Application no: **3/2019/0771**

Address: **40a Knowsley Road, Wilpshire Road, Blackburn, BB1 9PX**

Proposal: **Construction of a two car carport on the southern boundary of the property**

Block Plan shows area bounded by: 368623.83, 432100.34 368659.83, 432136.34 (at a scale of 1:200), OSGridRef: SD68643211. The representation of a road, track or path is no evidence of a right of way. The representation of features as lines is no evidence of a property boundary.

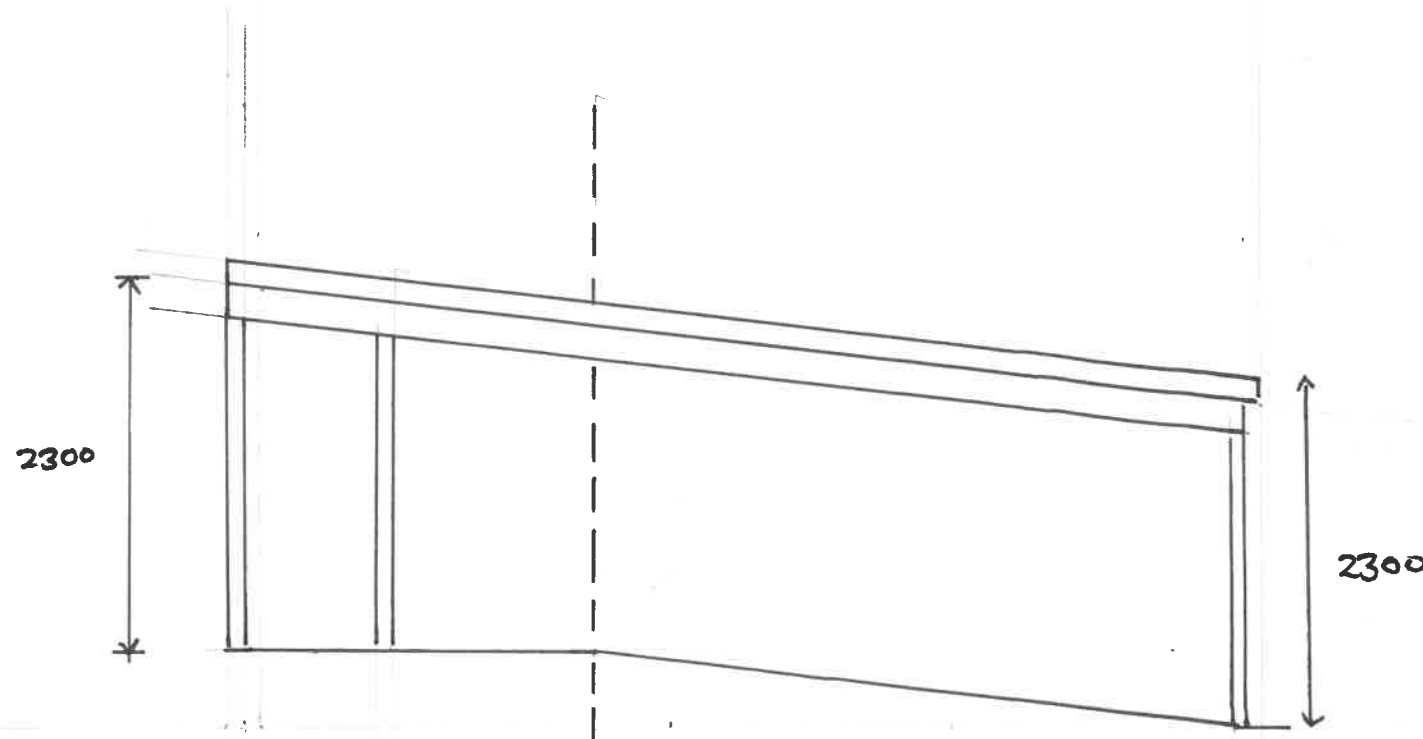
exceed this and given the privately shared access lane serves a number of further properties within close proximity of the application site, the local highway authority would require a dedicated plan which demonstrates the proposed parking arrangements at the application site.

The carport is to be sited within the curtilage of the property which is considered sufficient, however as the shared access lane is used by neighbouring properties and also the public via the public right of way, namely 3-46-FP 21 which runs past the property, the applicant will need to demonstrate how the associated parking arrangements will not obstruct the shared access lane to which shall remain free from obstruction at all times.

The Local Highway Authority will require the plans to be revised illustrating the proposed parking arrangements.
